Energy Assessments  
Department of Planning & Environment  
Locked Bag 5022  
PARRAMATTA NSW 2124

**SSD-23700028 for Tallawang Solar Farm at Castlereagh Highway, Tallawang.  
(various land parcels)**

30 November 2022

PROJECT	TALLAWANG SOLAR FARM
TITLE	EXTERNAL INTERSECTIONS CASTLEREAGH HIGHWAY / SOLAR FARM ACCESS INTERSECTION PLAN - CHR / AUL
DRAWING No.	20-010-INT3-4
REV	E

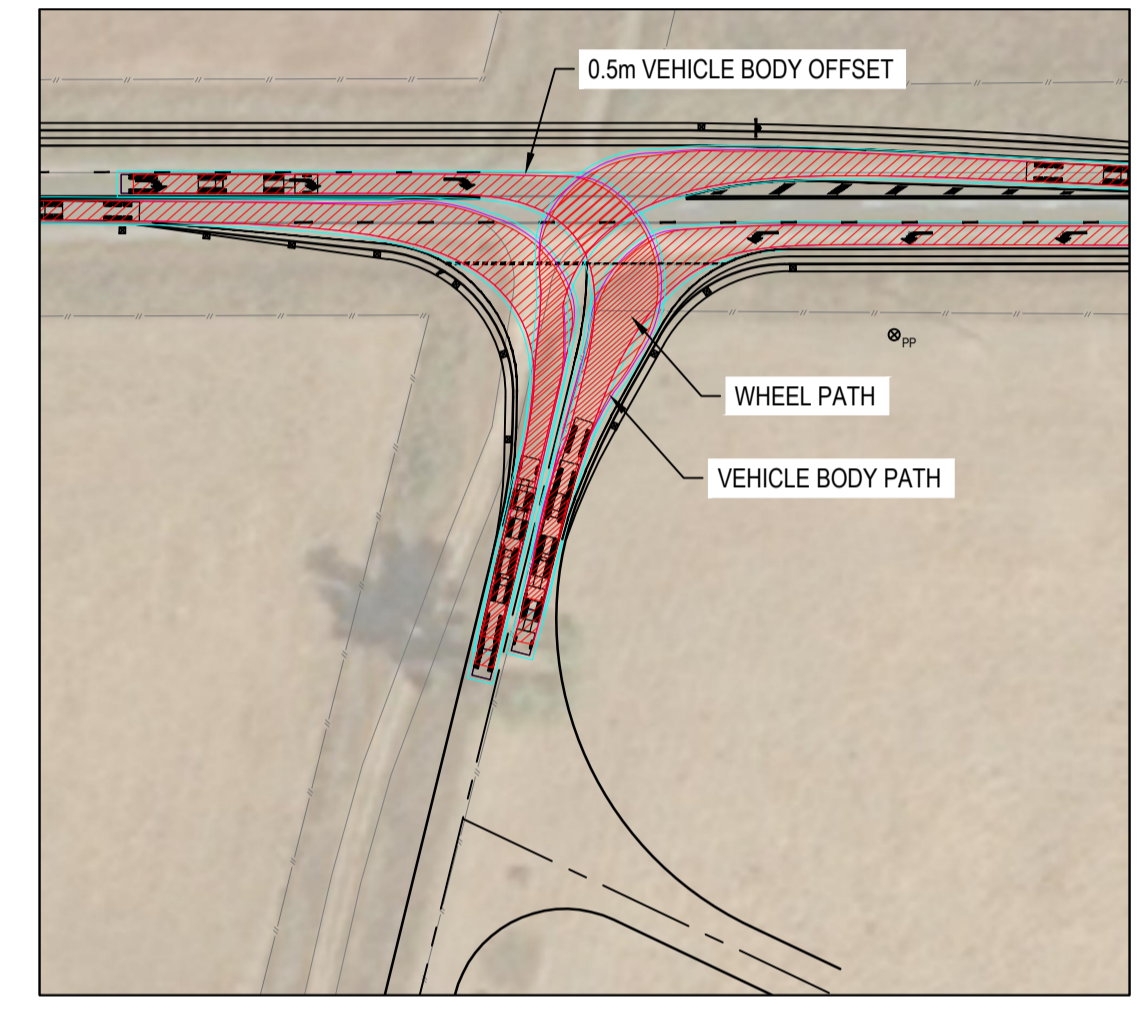
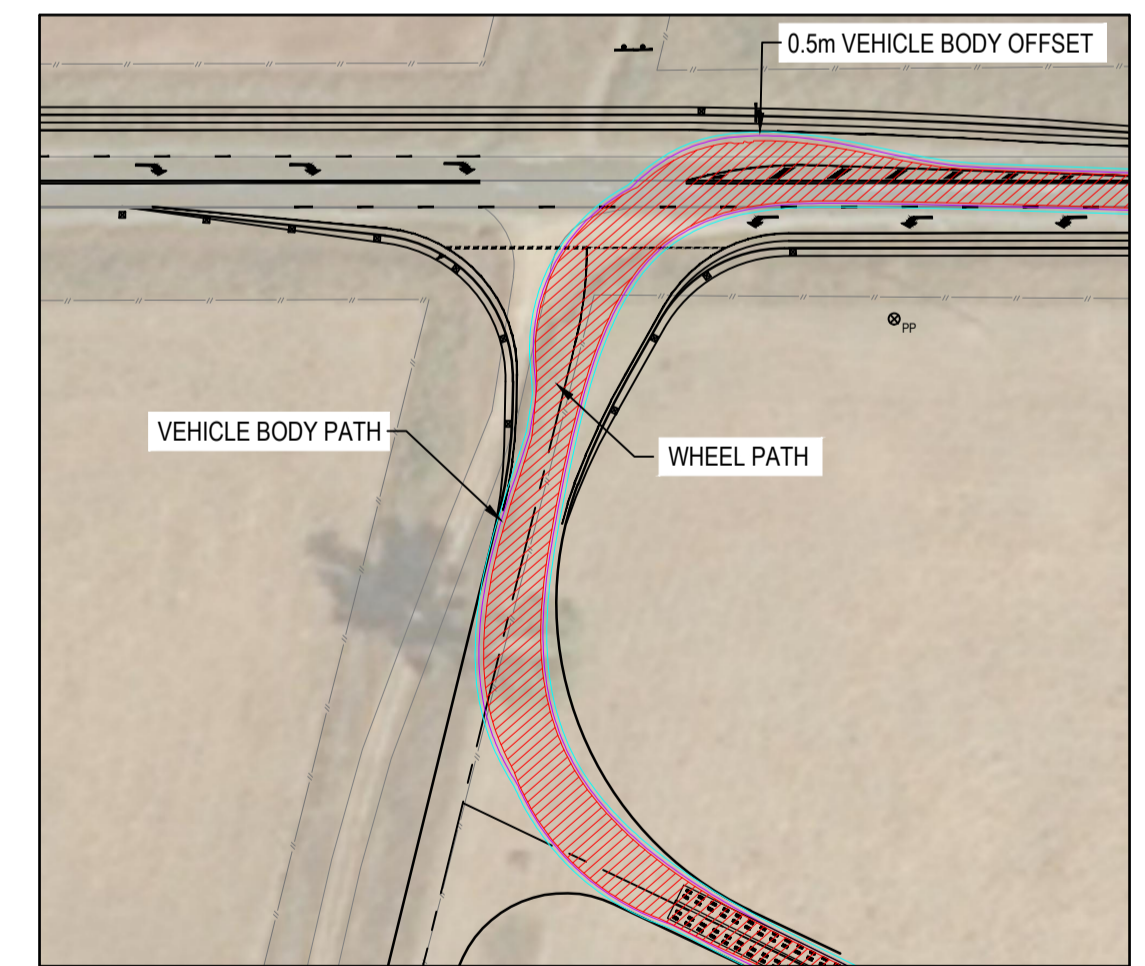
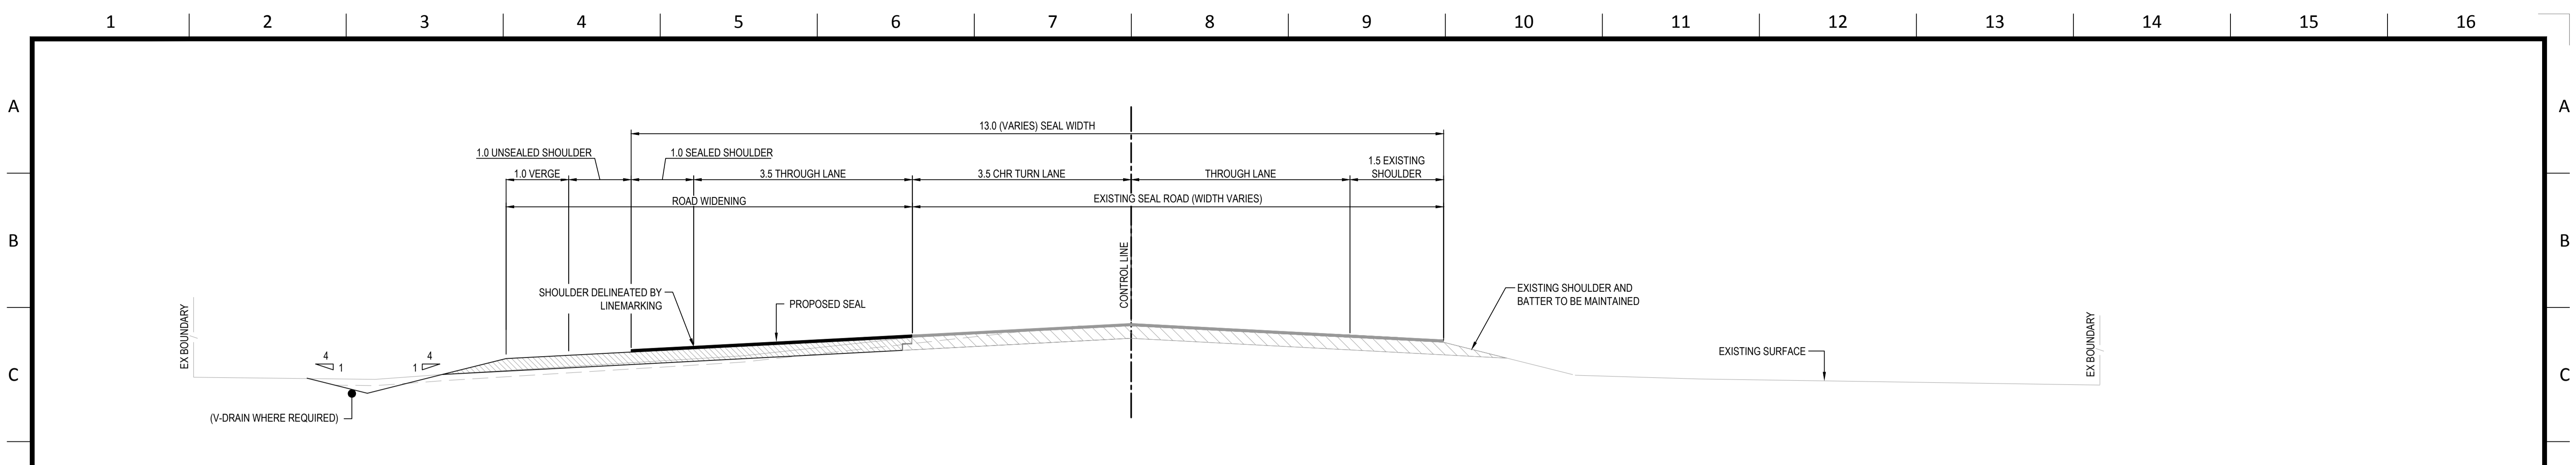
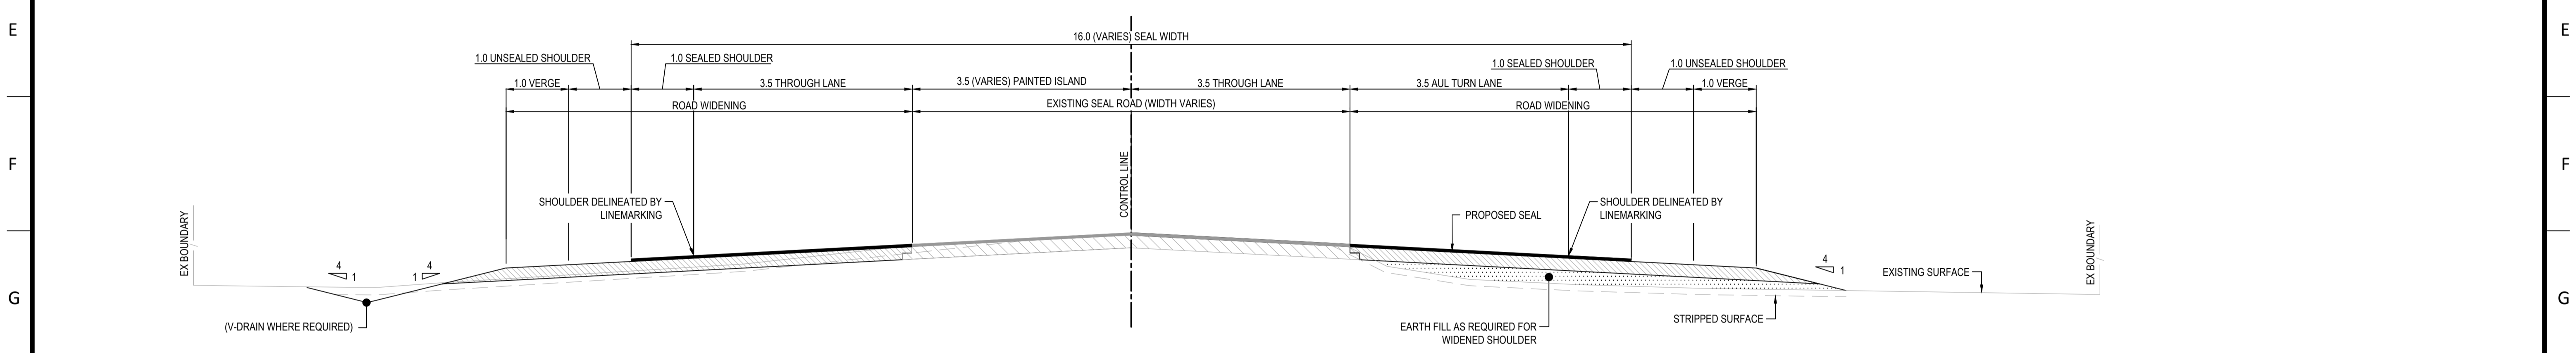
- *Appendix19 - Concept drawings for Project access*, includes a BAR / BAL design in addition to a (short) CHR / AUL. It is unclear why the BAR / BAL has been provided, as it is not addressed in the TIA or the EIS. Notwithstanding this, TfNSW does not consider a CHR(s) is sufficient to provide the required storage length, to accommodate the proposed turning (construction) traffic volumes.

- *Appendix19* further shows a section of unsealed road between the site access and the Castlereagh Highway intersection proposed upgrades along Jacksons Lane. TfNSW requires Jackson Lane be sealed between the site access and intersection connection to the Castlereagh Highway (inclusive of all proposed works), to reduce the extent of wear and road damage.

- The intersection upgrade is to include standard (full sized) CHR & AUL turn treatments, designed and constructed in accordance with the relevant *Austrroads Guidelines*, *Australian Standards* and related *TfNSW Supplements*, demonstrating all relevant line-marking, with 3.5m lane widths, 1m wide centre line, 2m sealed shoulders (addition to turning lanes), 1m verge & 6:1 or flatter batters.

- The extent of the proposed sealed road surface, to further include the full section of Jacksons Lane between the site access and the Castlereagh intersection connection (inclusive of the site access).

- Dedicated swept path diagrams, clearly identifying the size & type of the relevant design vehicles, the swept path of both the wheel base, any vehicle (load) overhang and stationary vehicle positioning demonstrating the largest design vehicle will be able to safely and efficiently arrive and depart the key intersection in both directions to access the site, travelling wholly within the required travel lanes and no additional works will be required to accommodate those vehicles. Over Sized Over Mass (OSOM) swept paths should include pull-over bays required to undertake the required traffic control processes to enable the required turn movements.
